From: Laura Gibbons
Sent: 22 January 2019 12:49
To: Planning.Responses
Cc: Michael Eastham
Subject: RE: Planning Consultation on: BE/135/18/PL

Engineers Comments Regarding Surface Water Drainage

APPLICATION BE/135/18/PL

Site Address: Salt Box Field Land off Rowan Way Bognor Regis PO22 9NW

PROPOSED PEAK SURFACE WATER DISCHARGE FLOW RATES AND ATTENUATION TABLE			
CATCHMENT AREA	PROPOSED FLOW RATE	PROPOSED ATTENUATION FOND	
1	11.30 L/S	3,900m ³	
2	2.00 L/S	500m ³	
3	10.30 L/S	3,250m ³

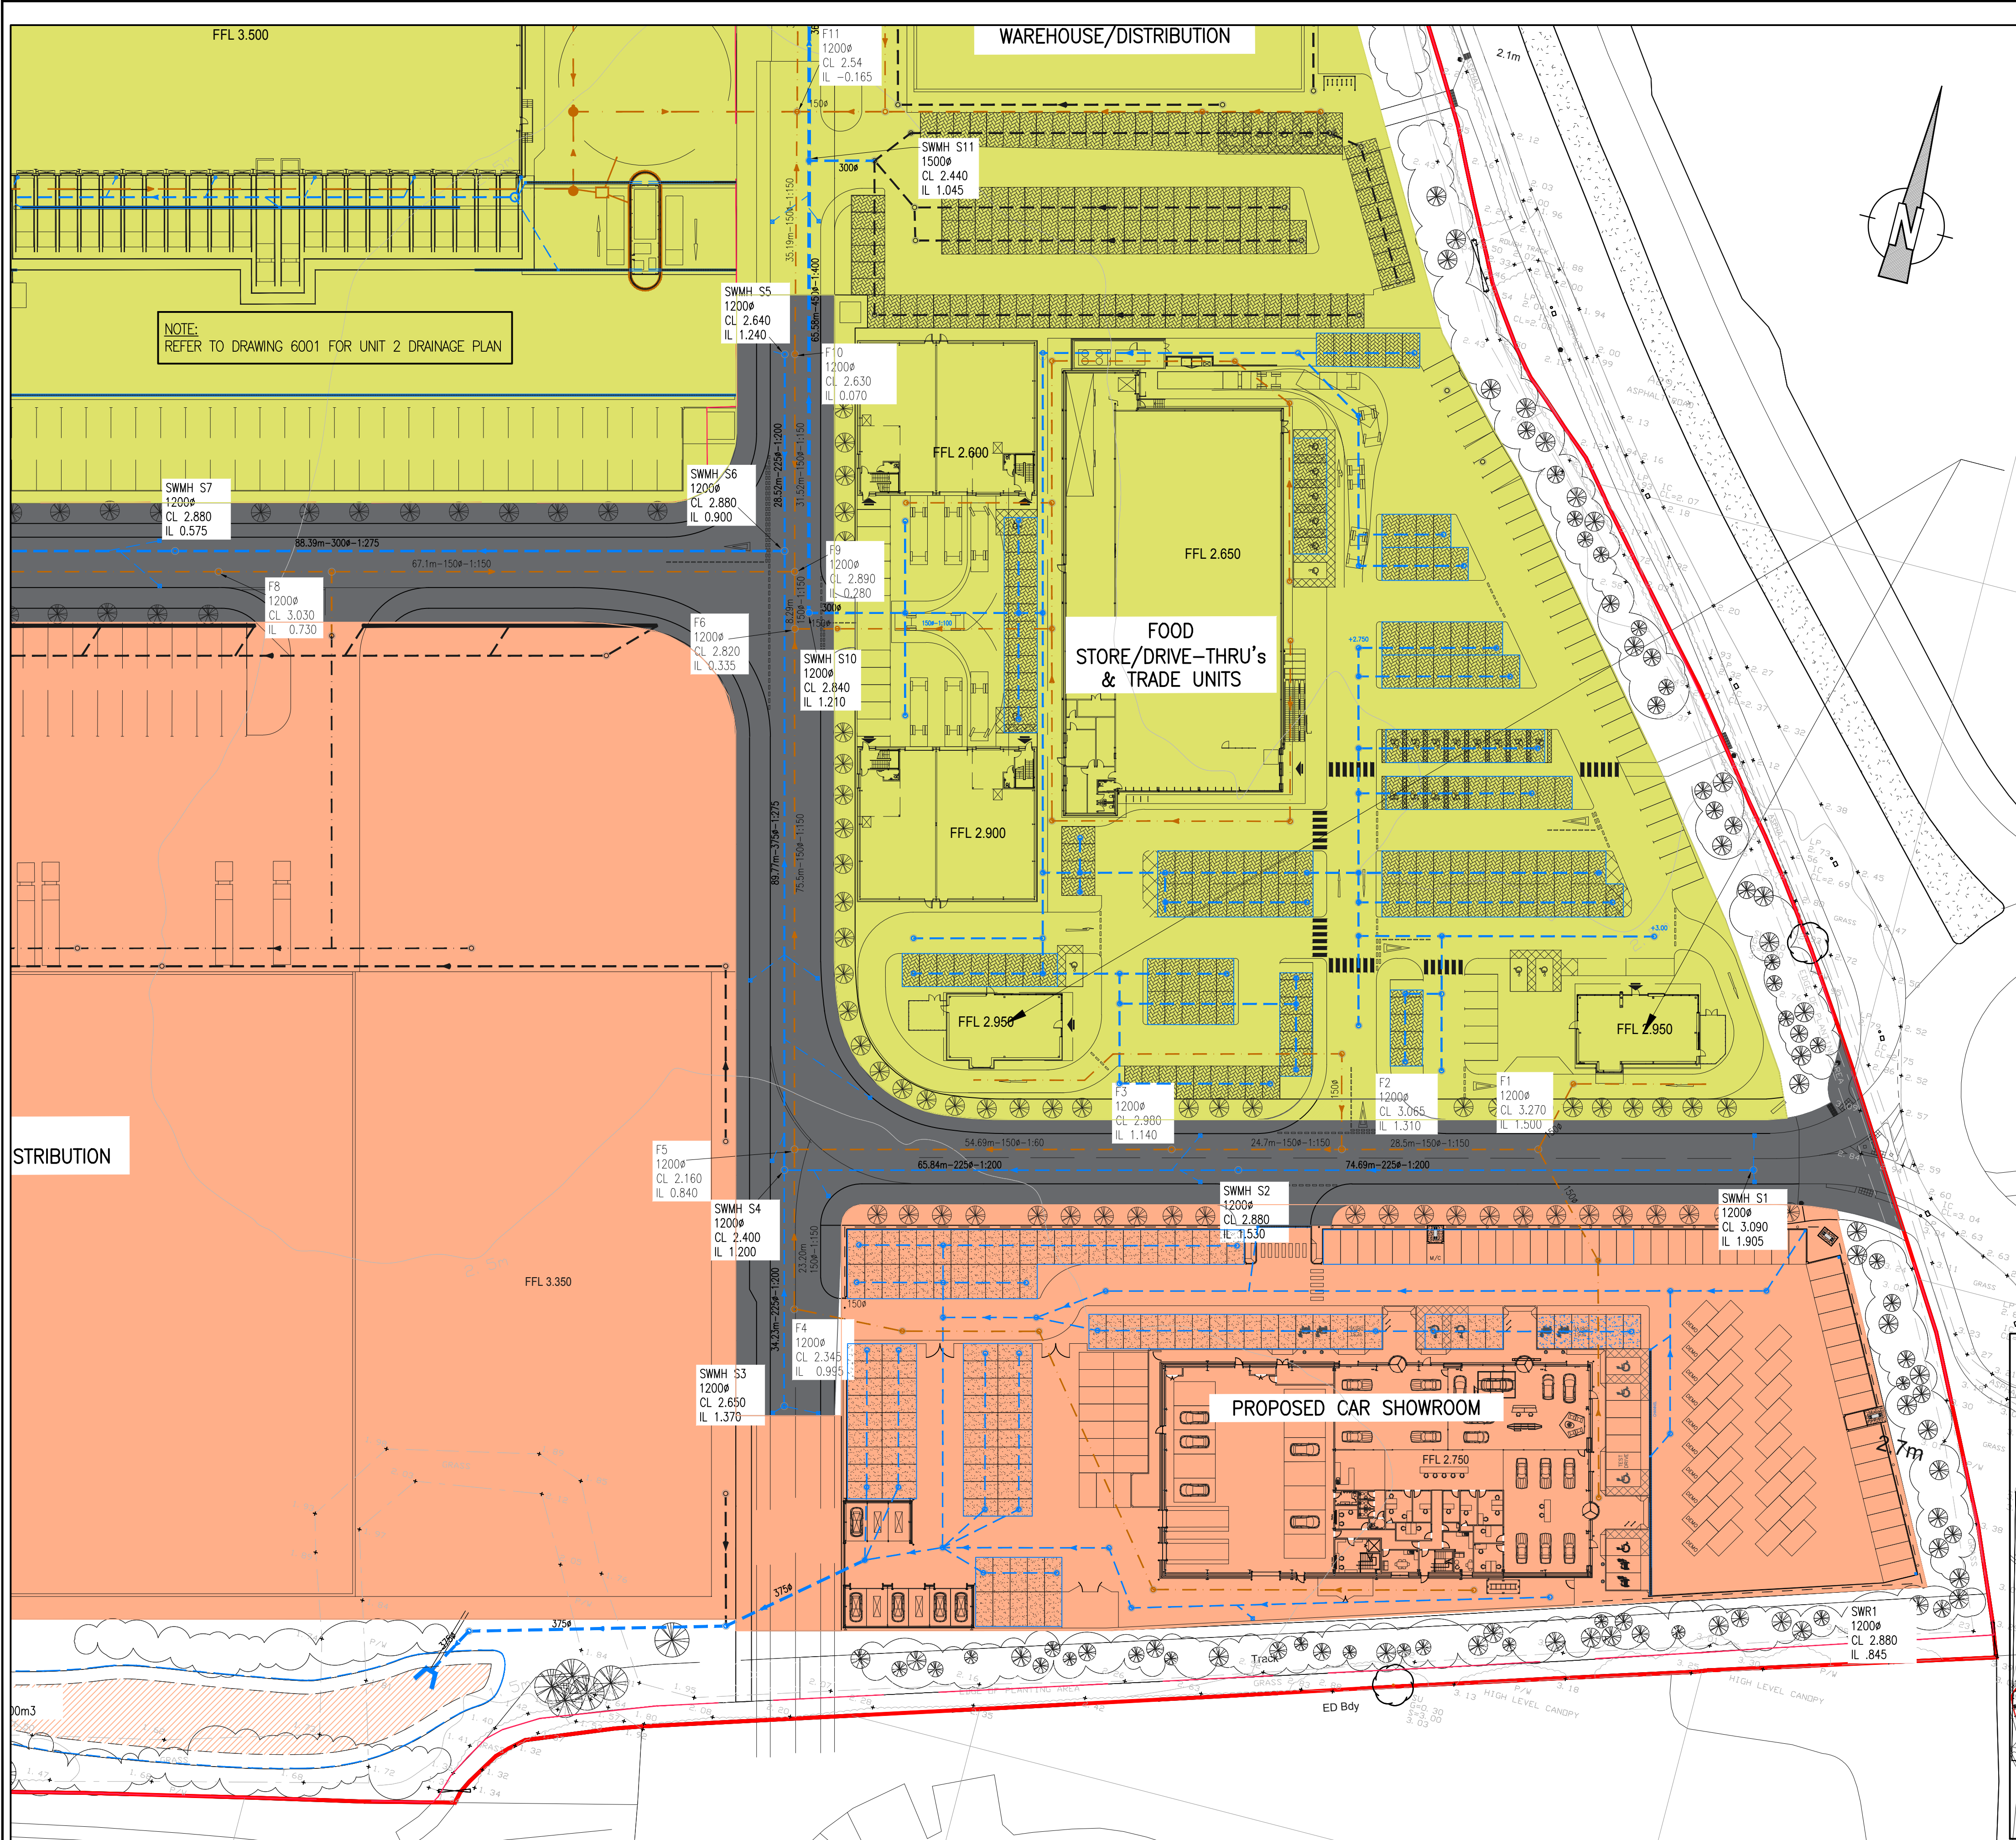
The proposals currently show that attenuation and controlled discharge to watercourse (both main river and ordinary watercourse) are proposed. No evidence has been submitted to demonstrate that infiltration is not viable.

Infiltration must be investigated.

Infiltration rates for soakage structures are to be based on percolation tests undertaken in the winter period and at the location and depth of the proposed structures. The percolation tests must be carried out in accordance with BRE 365, CIRIA R156 or a similar approved method and cater for the 1 in 10 year storm between the invert of the entry pipe to the soakaway, and the base of the structure. It must also have provision to ensure that there is capacity in the system to contain below ground level the 1 in 100 year event plus 40% on stored volumes, as an allowance for climate change. Adequate freeboard must be provided between the base of the soakaway structure and the highest recorded annual groundwater level identified in that location.

Any SuDS or soakaway design must include adequate groundwater monitoring data to determine the highest winter groundwater table in support of the design. The applicant is advised to discuss the extent of groundwater monitoring with the Council's Engineers. Supplementary guidance notes and our surface water drainage submission checklist are also enclosed for information.
